**KIRKLEES METROPOLITAN COUNCIL
INVESTMENT & REGENERATION SERVICE**

DELEGATED DECISION TO DETERMINE PLANNING APPLICATIONS

Reference No: 2021/62/90219/W

Description: Erection of extensions and alterations to garage create dwelling forming annex accommodation associated with 5, Park Riding, Northgate, Honley, Holmfirth, HD9 6QL

01 Front Elevation
1:50

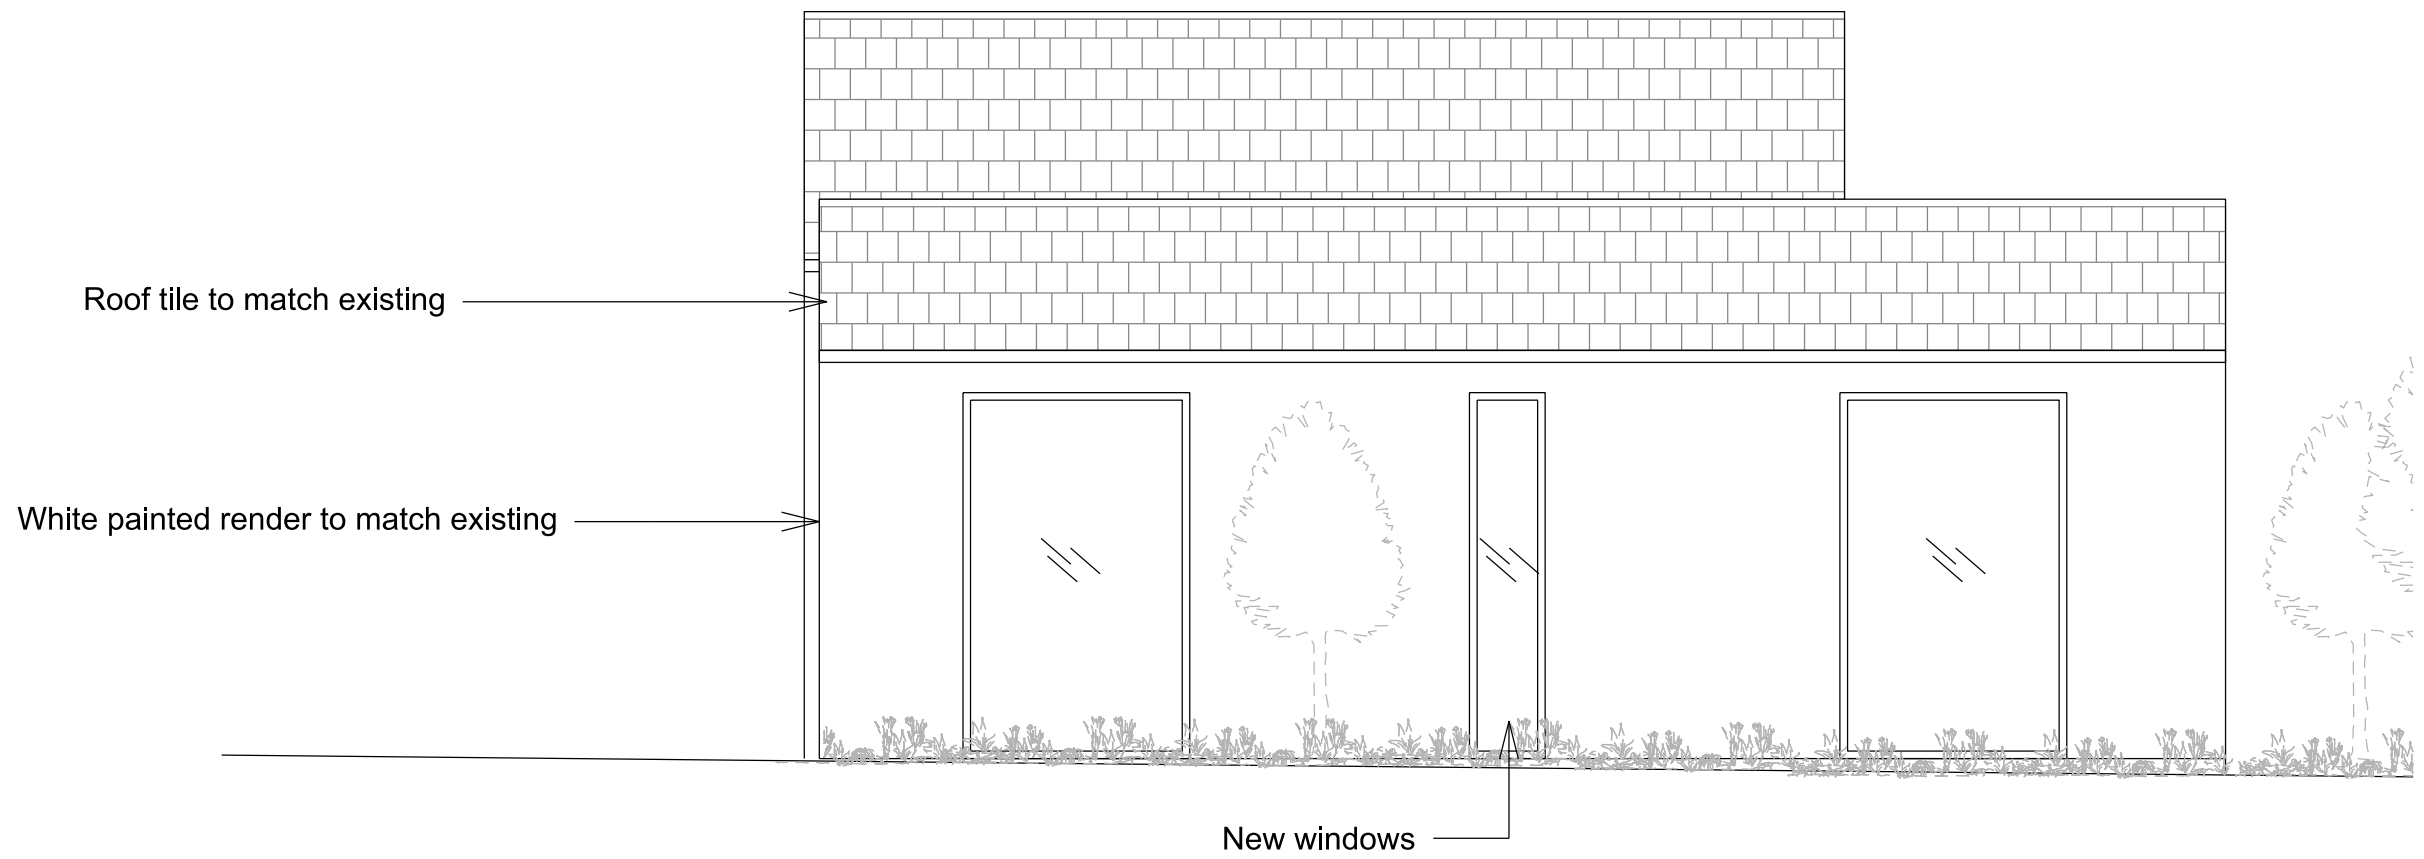
Amendments have been sought to amend the red line boundary of the application site due to concerns over land ownership. Additional alterations were also requested to the submitted plans to reduce the overall scale and size of the proposed annex and remove some of the proposed hardstanding to the side of the building in the interests of visual amenity and the impact on the openness of the Green Belt.

- The proposed annex would have a footprint nearly as large as that of the applicant's main house. This would alter the scale, character, and balance of building within the whole of the Park Riding curtilage and would impact on the visual amenity of the area;

- The design and materials proposed are not in keeping with the character of the adjacent listed building in a conservation area;

Further amendments were made to reduce the overall scale and size of the annex; however, re-consultation was not undertaken on this issue as it bore no relationship with landownership or car parking issues, it also sought a reduction in massing which in turn reduced concerns for visual and residential amenity. It is in officer's opinion that no third party would be negatively impacted by the decision not to re-consult in this instance.

The scale of additions to the property, combined with the design of the extension which is single storey in scale, has a ridge height set down from the main body of the garage and the fact that it replaces a former addition to the garage is considered to sufficiently demonstrate that the building would not represent a disproportionate addition to the property. Furthermore, it is noted that a greenhouse that was previously attached to the garage until very recently and evident on the site photographs has been removed to facilitate the extension, further reducing built form at the site. Turning specifically to the design of the proposal, it would lead to the garage have a generally contemporary feel with large sections of glazing. Such an approach is not opposed subject to an assessment on its impact on the adjacent listed building which is undertaken below. The addition to the garage is considered to be clearly read as a subservient addition to the original building given the

ridge height is set down and the slight set back from the front elevation. The use of matching materials would help it to harmonise with the existing building. The design of the extension is therefore considered to be acceptable.

Drawing Title
Site Plan

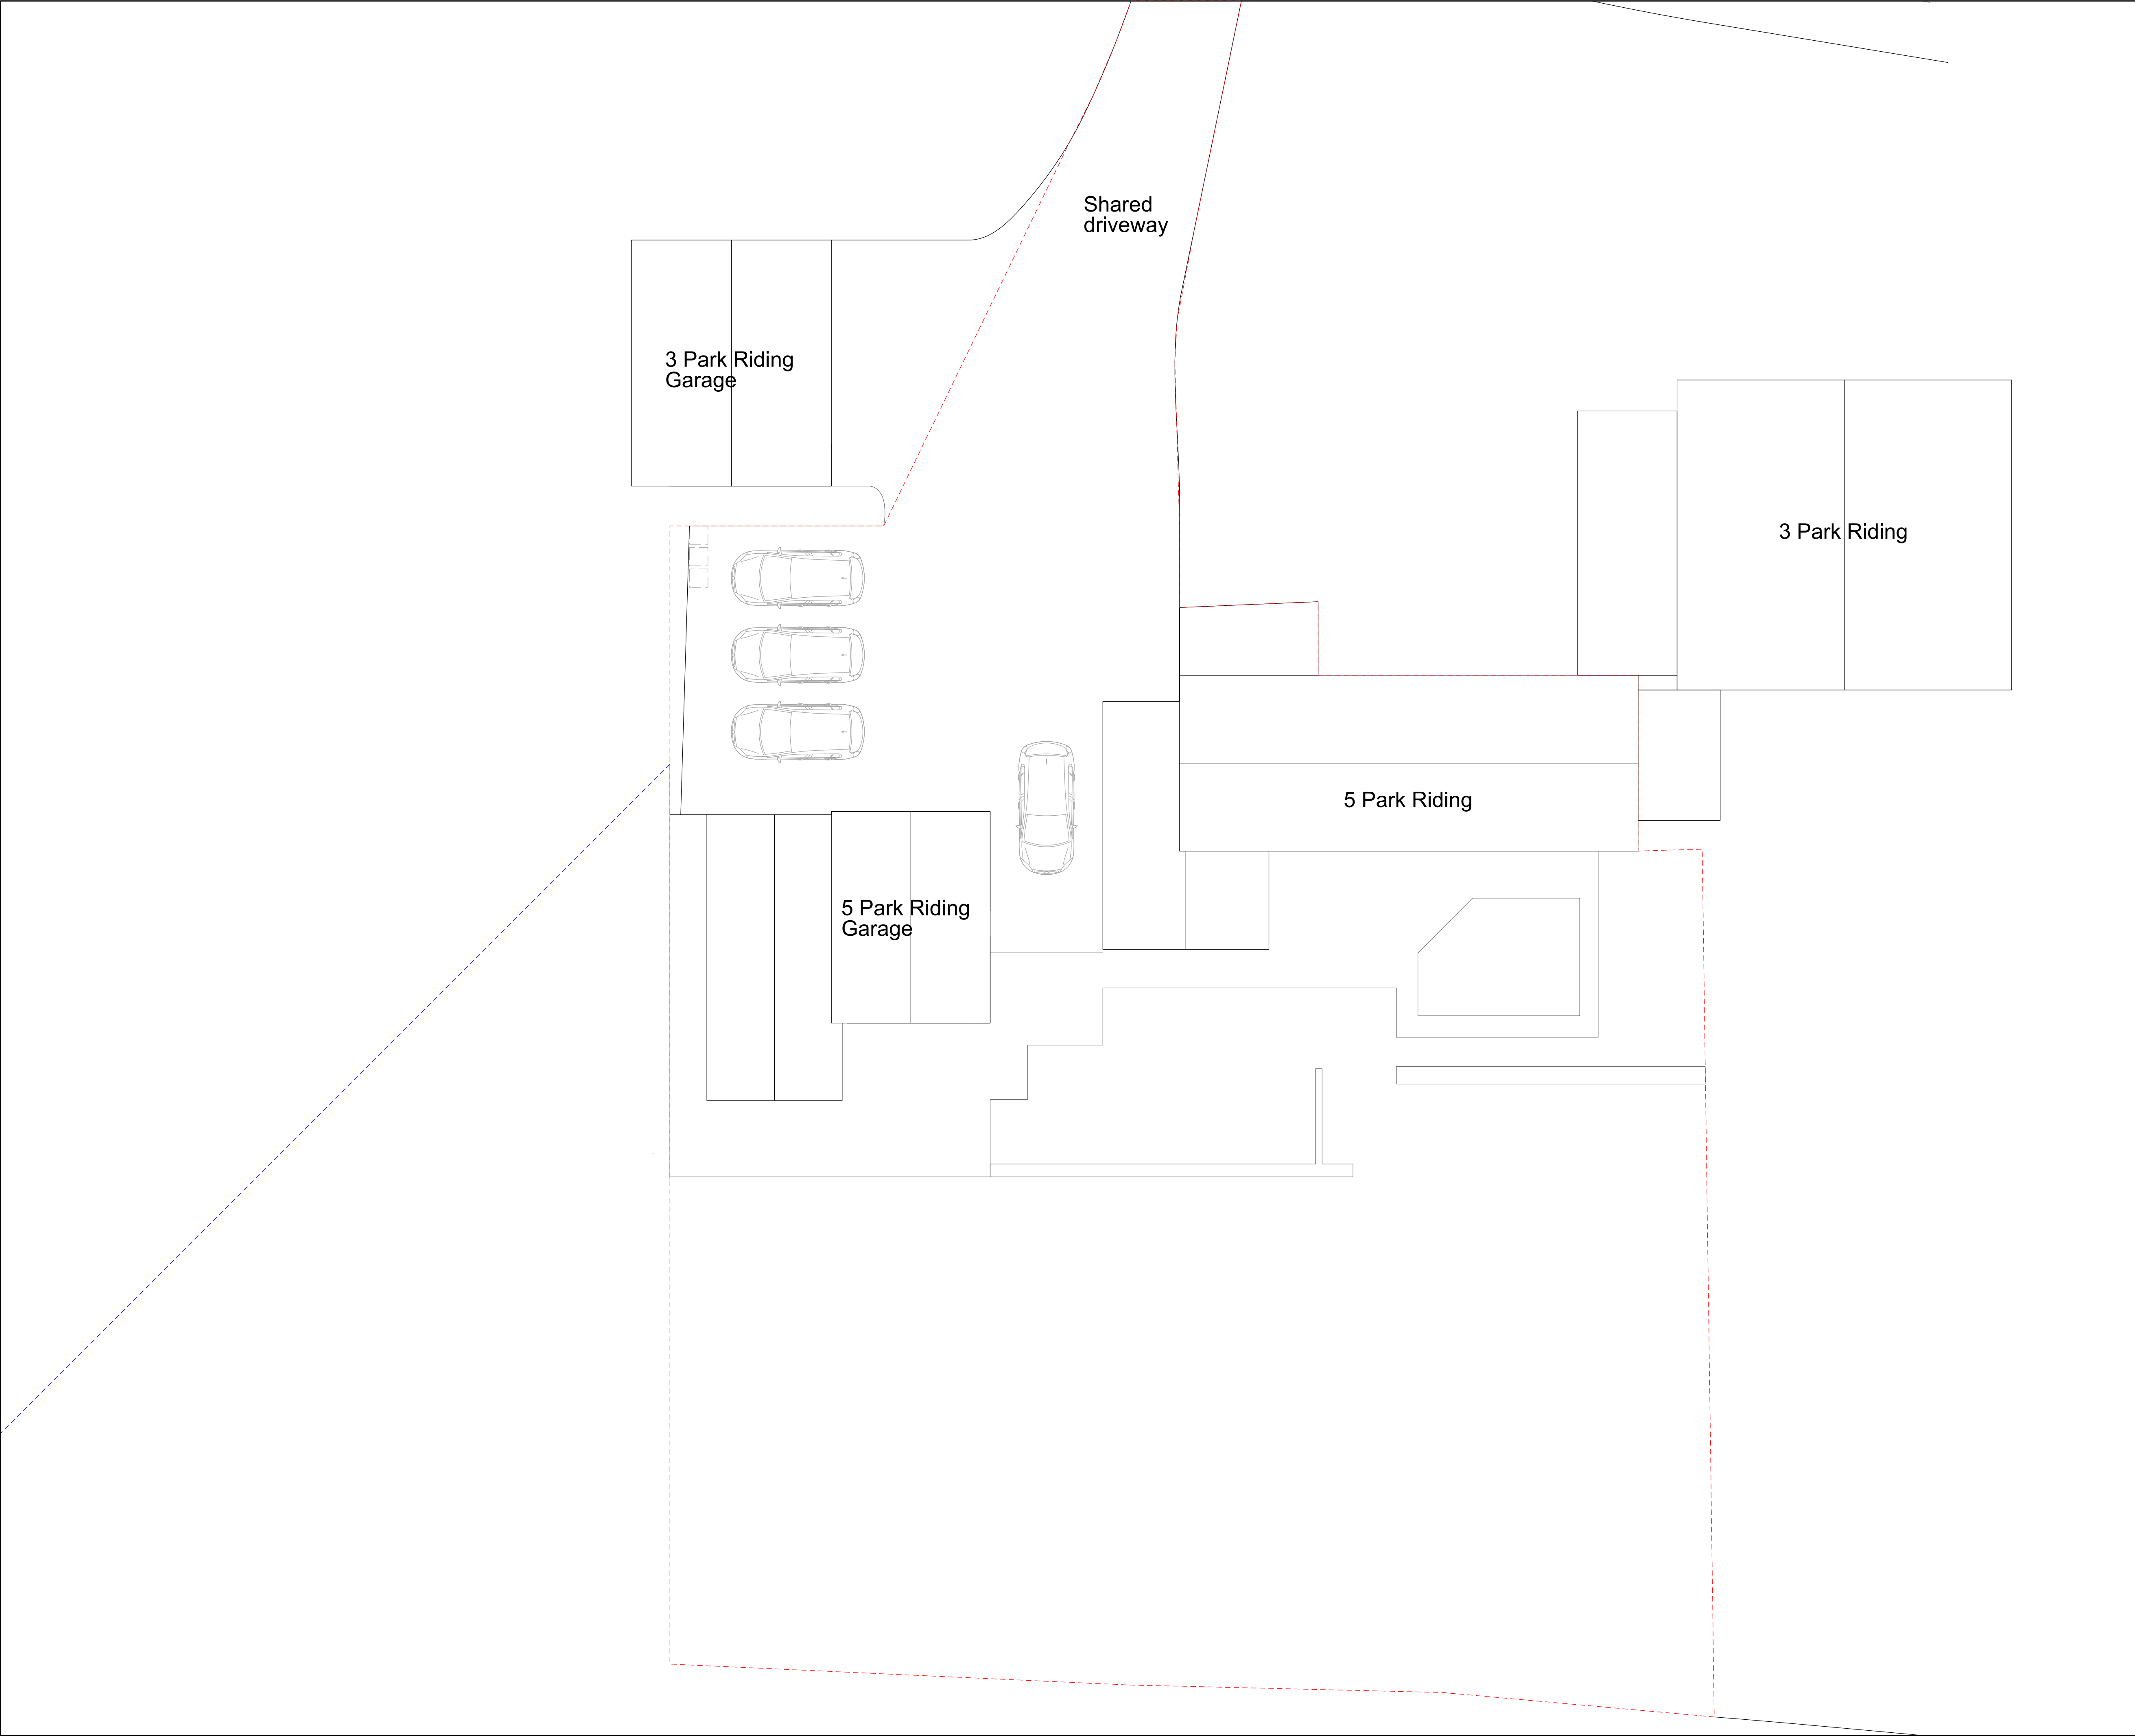
- The boundaries of the applicant's property have been inaccurately shown on these plans as they include part of the driveway owned by no. 3 Park Riding. The applicant merely has a right to pass and repass over that part of the drive outside of their ownership subject to the applicant paying one half of the cost of repairing and maintaining the drive. Any increased user of this right of way would be inconsistent with this right which was determined at the date of conveyance in 1997;

- Part of the extension and path may extend into the adjoining field of which is in the ownership of no. 3 Park Riding. If this were to be the case then such encroachment would be in breach of a covenant which restricts and building on this adjoining land, and obstruct the existing right of way which provides access for the owners of the adjoining land;

Officer note: Noted. Amended plans have been provided to rectify any concerns over landownership.

Officer note: Following on from numerous discussions with the applicants agent and submitted land registry details it is confirmed that the proposals would not encroach into the adjacent field.
